Drainage Assessment - Event Parking Area.

50 Peter Brock Drive, Eastern Creek,
NSW

P2108122JR02V01

April 2021

DRAWING TITLE				
DRAINAGE DETAILS SHEET 1				
PROJECT NO.	PLANSET NO.	RELEASE NO.	DRAWING NO.	REVISION
P2108122	PS01	R04	PS01-E200	B

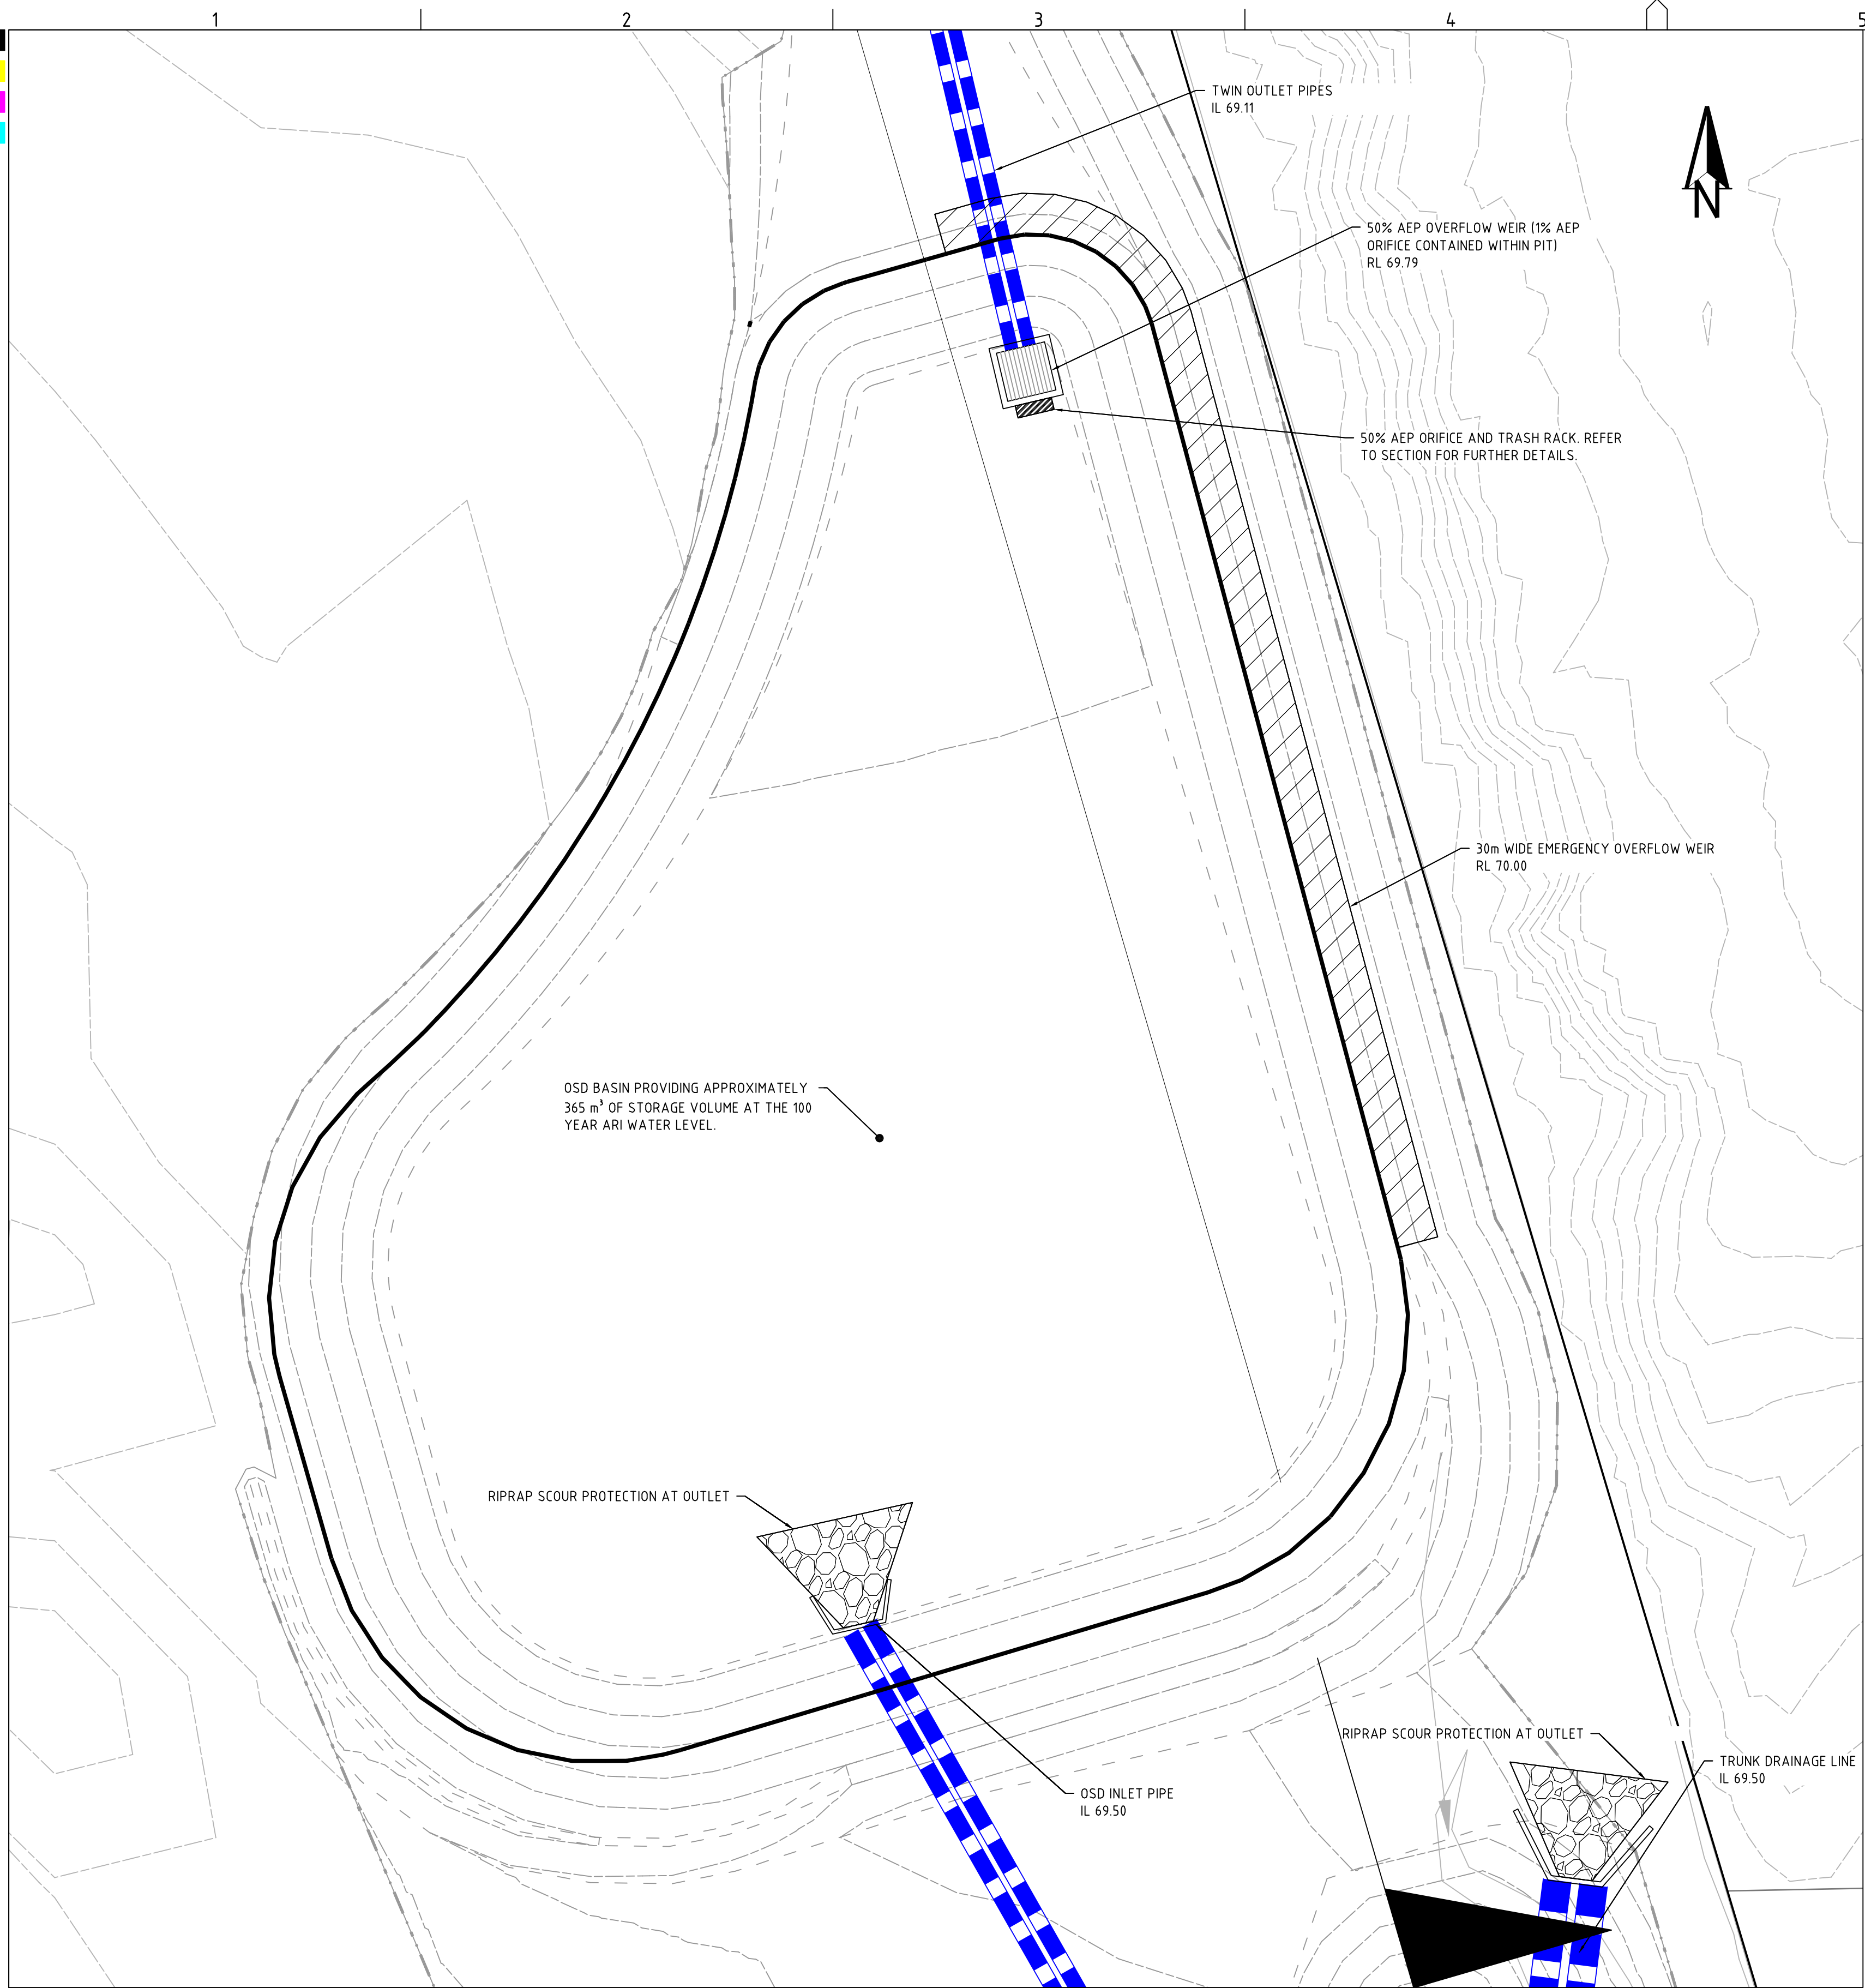
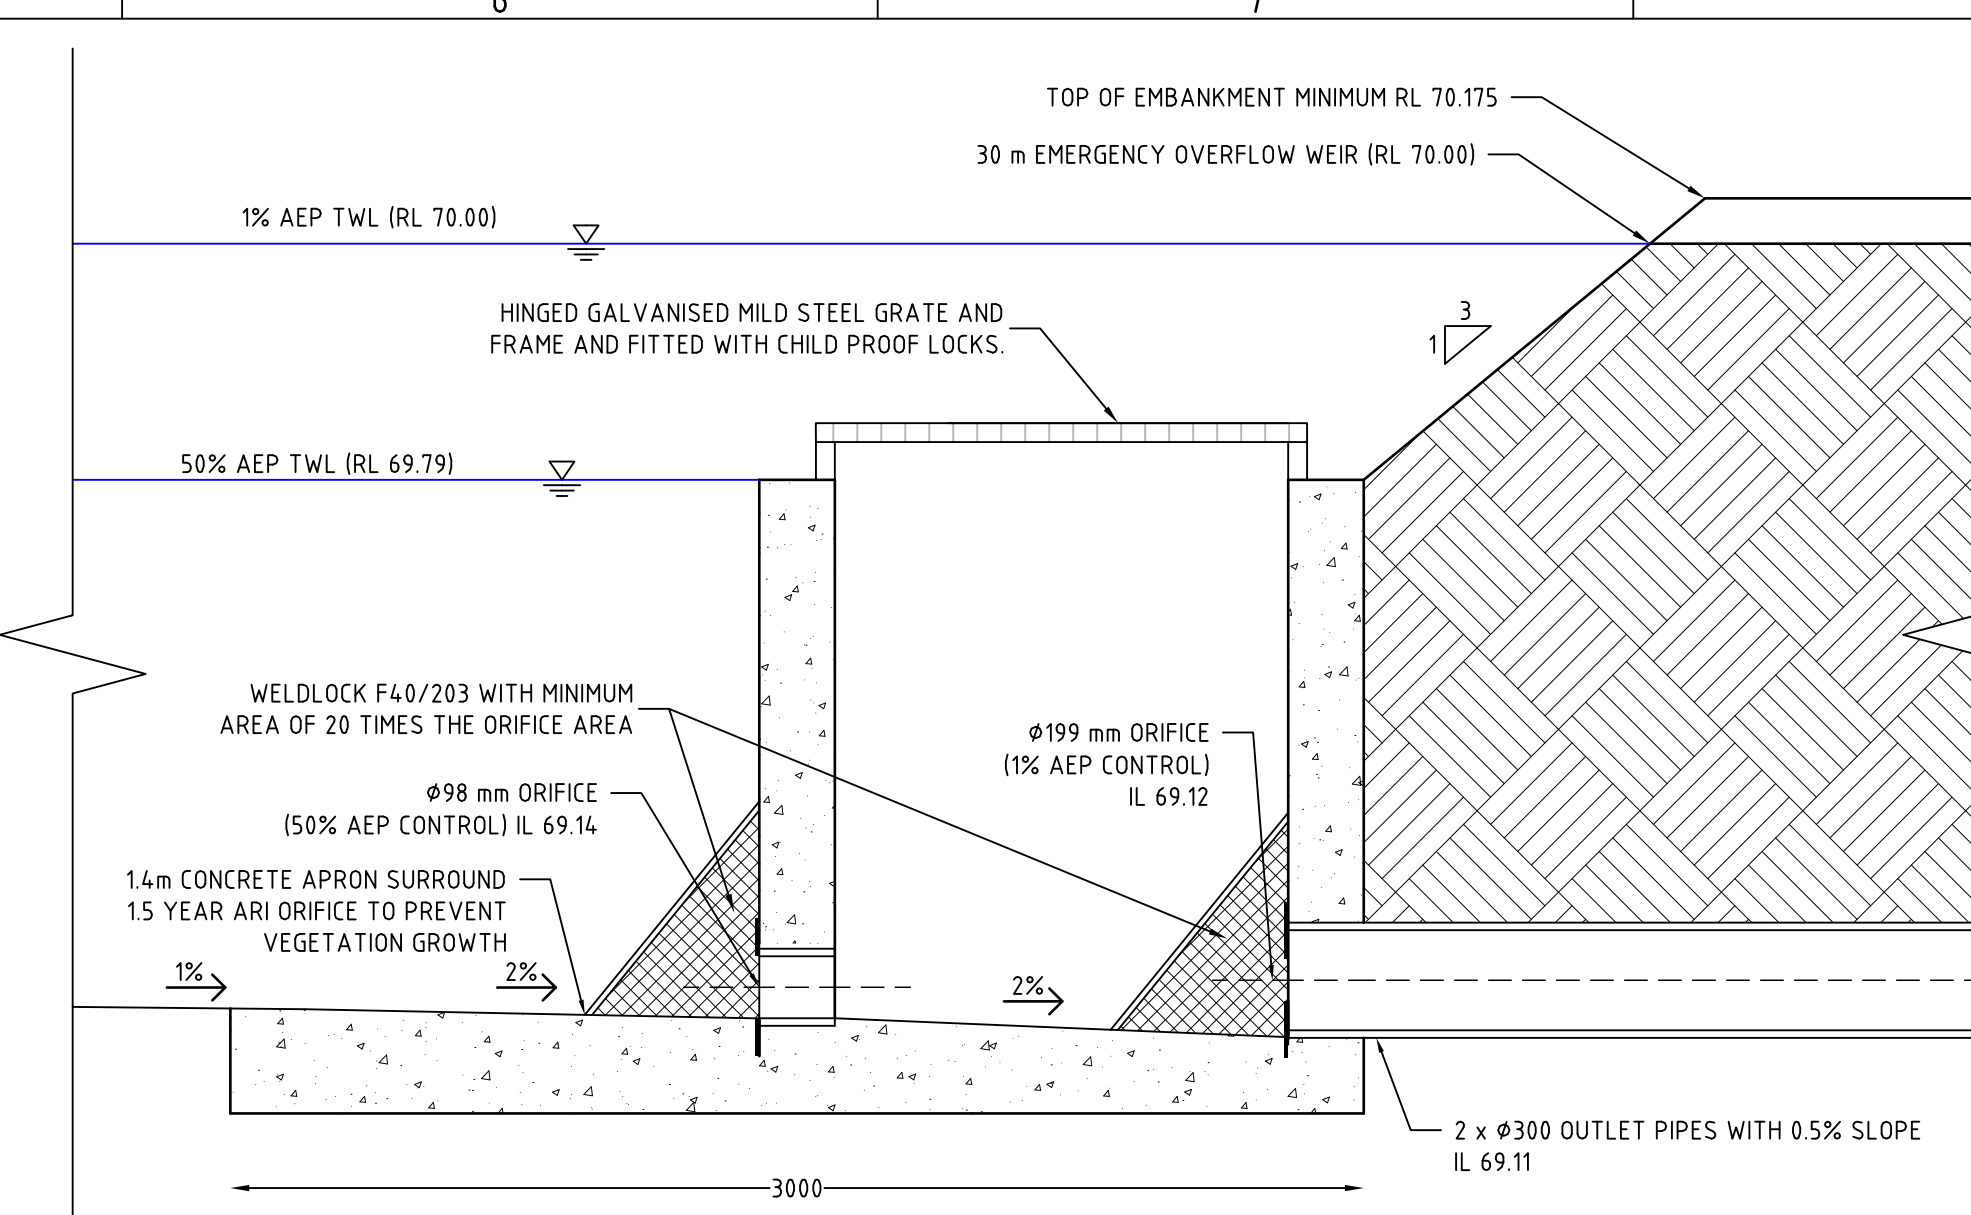
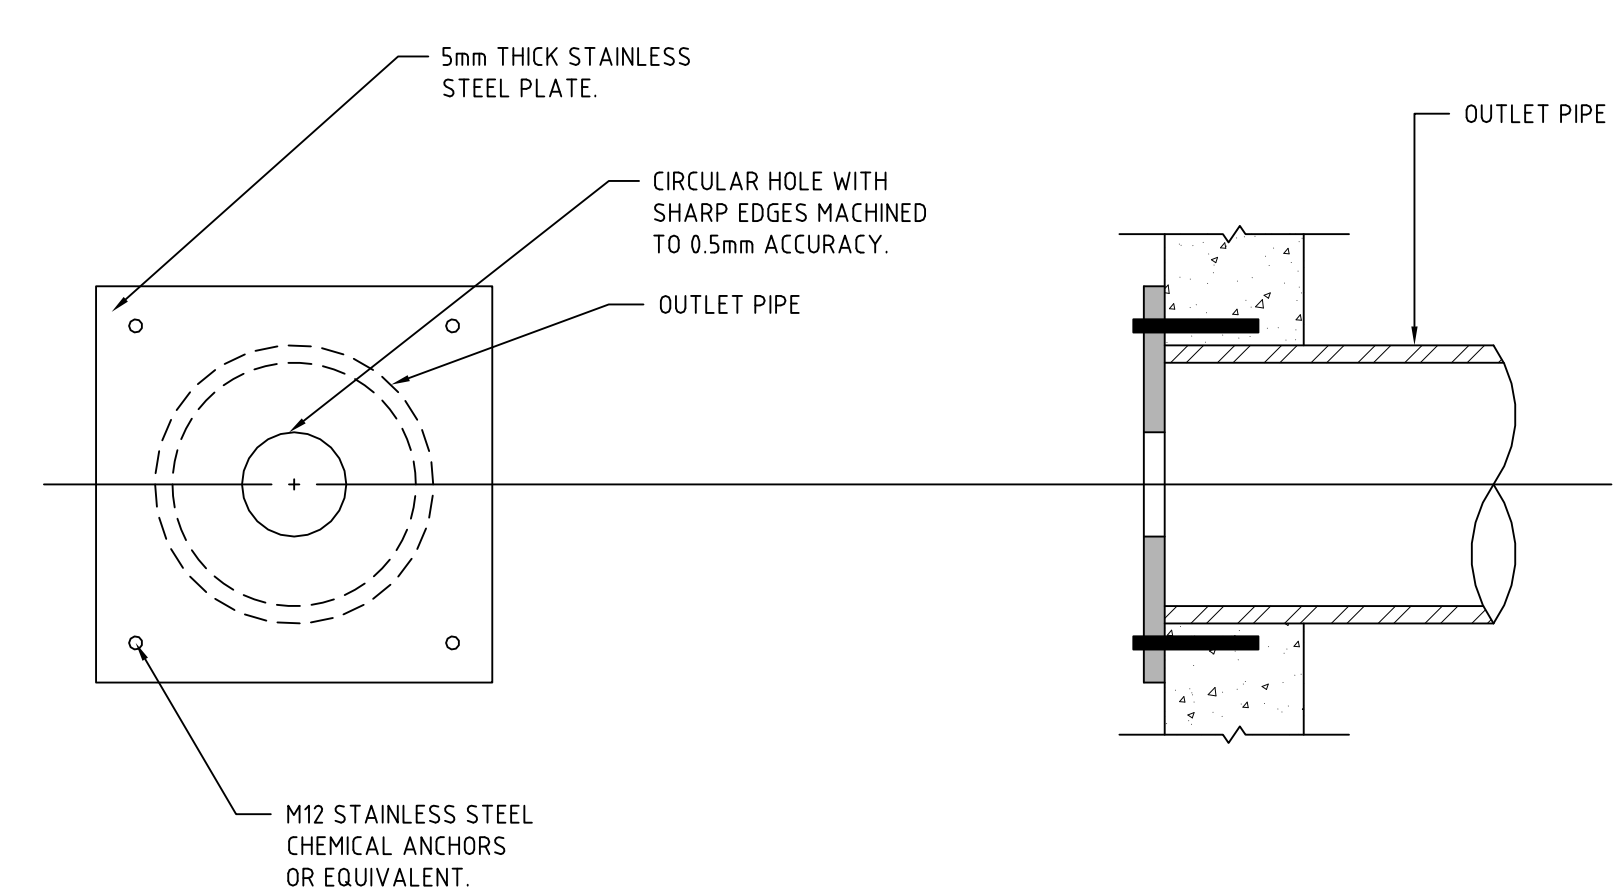
RFI Issue	Response / Comment
7.4 On-Site Detention <i>Given that gravel or bitumen sealing impacts on the previously existing impervious fraction at the subject site, impacts of increased runoff should be managed using a suitable on-site detention system designed in accordance with the Council-designated detention rate of 455 m³ per hectare or other suitable method acceptable to Council. The design of the system to be prepared by the Engineer for further consideration.</i>	OSD has been provided for the Event Parking Area in accordance with BCC's required rate of 455 m³/ha by following BCC's deemed to comply spreadsheet. Refer to Section 4 for further details.

OSD storage has been designed in accordance with BCCs deemed to comply spreadsheet tool. The site requires approximately 240 m³ for the 50% AEP storm and 365 m³ for the 1% AEP storm. Refer to Attachment C - MA planset P2108122PS01 drawing PS01-E100 for the basin location and drawing PS01-E200 for basin details.
